ExQ2: RESPONSE OF NEWARK AND SHERWOOD DISTRICT COUNCIL

**Visual Receptors -
Scale of Change After Mitigation
Figure 7.7**

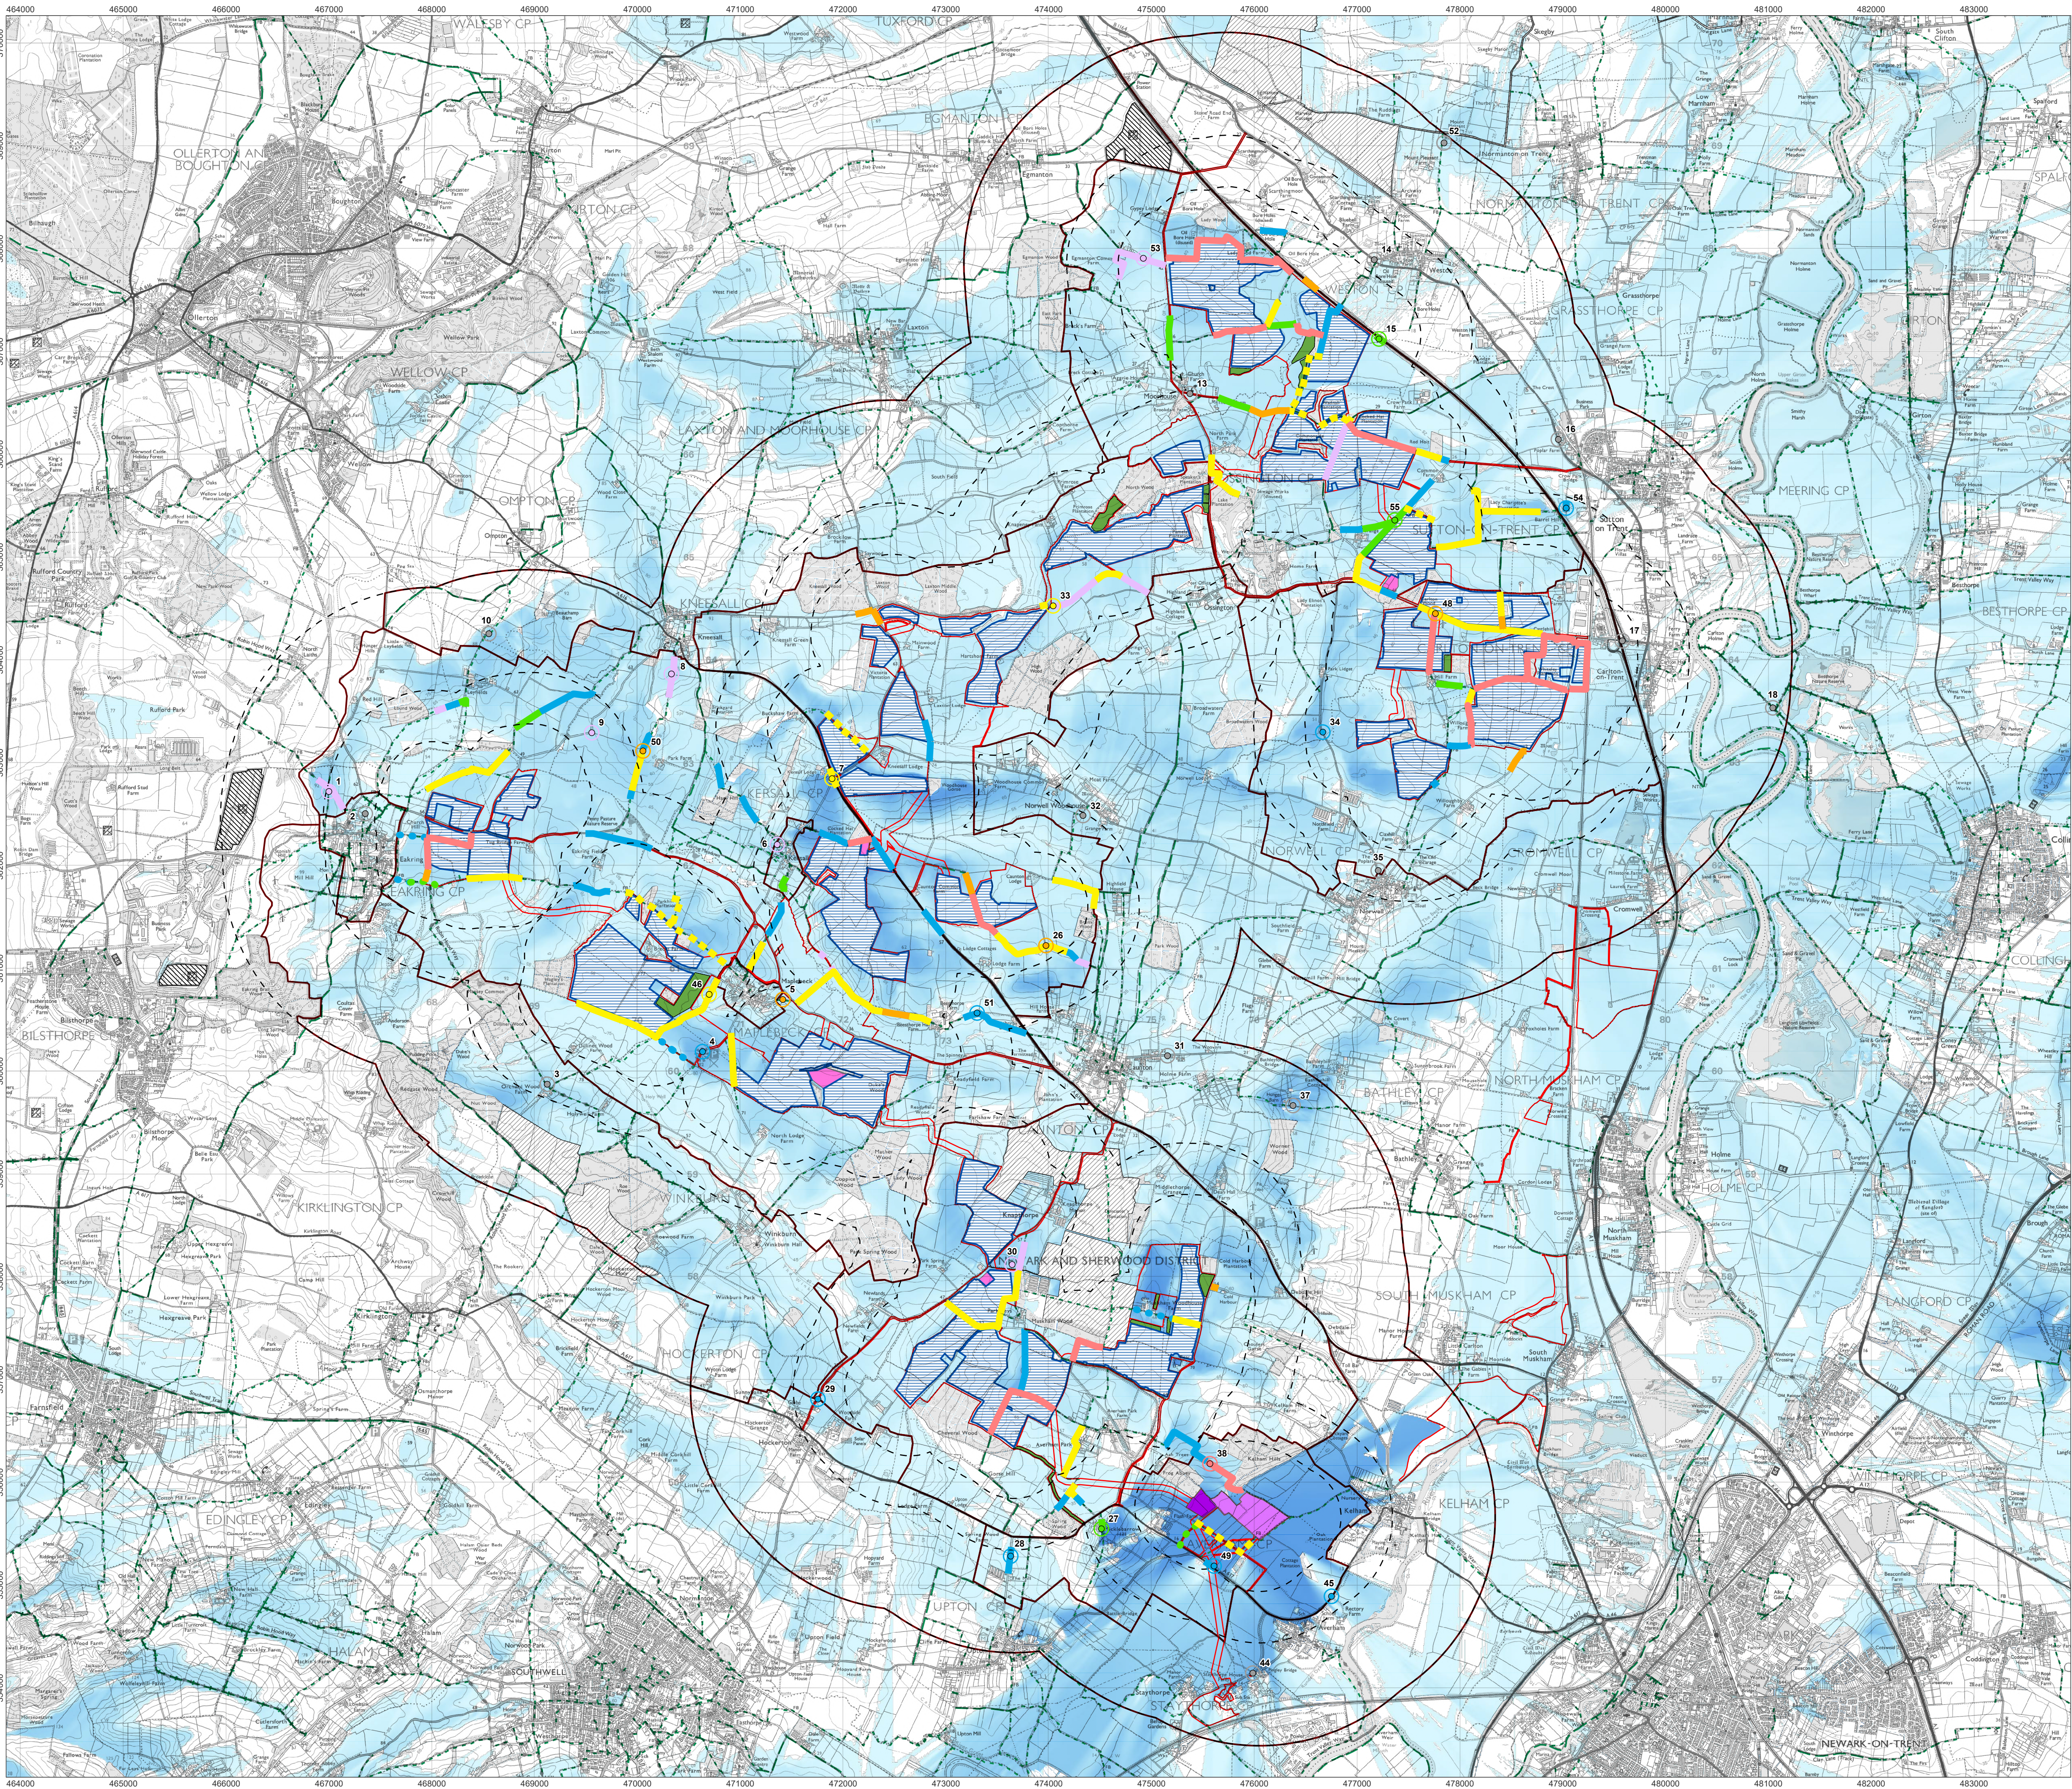
Group F Road users between Ossington and the A1/Carlton on Trent

This is with reference to the most northerly aspect of this part of Group F on the north and south side of Ossington road where the solar arrays will form an almost continuous experience – especially around Carlton on Trent. This is due to the open nature of the views across this landscape It is between Ossington and Carlton (not Thornton) and it is along Ossington Road. This is indicated in the mapping extracts below.

During construction and early operation this group is judged to be Major/Moderate which will be significant

During operation and decommissioning Major/Moderate adverse which will be significant
